From: [Karen Walter](#)
To: [Nicole Gaudette](#)
Subject: Headrick project, CAO19-014& 1905-249, Notice of Application for Critical Area Determination
Date: Monday, August 26, 2019 4:05:06 PM
Attachments: [WDFW Fish culvert barrier map for 8222 SE 62nd Street.pdf](#)

We have reviewed the available information for the Headrick project at 8822 SE 62nd Street, Mercer Island and offer the following comments:

Figure 2: Existing Site Conditions and Channel Measurement Location

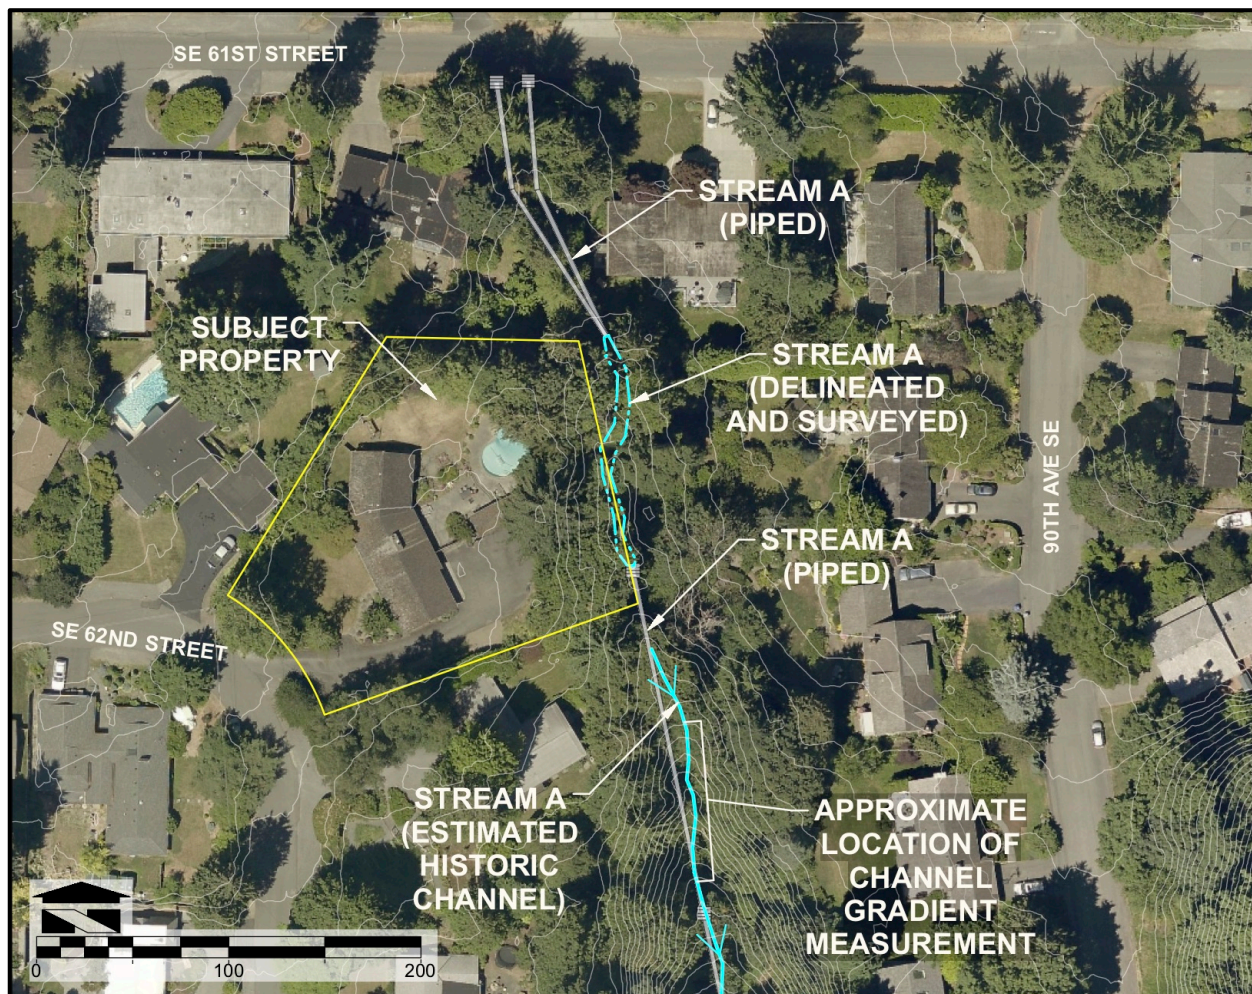
From a review of the site plan map showing the locations of the surveyed OHWM, it appears that the stream meets the criteria for bankfull width (i.e. >+2 feet). The streambed gradient is unknown at this time. More data is needed to establish the streams classification.
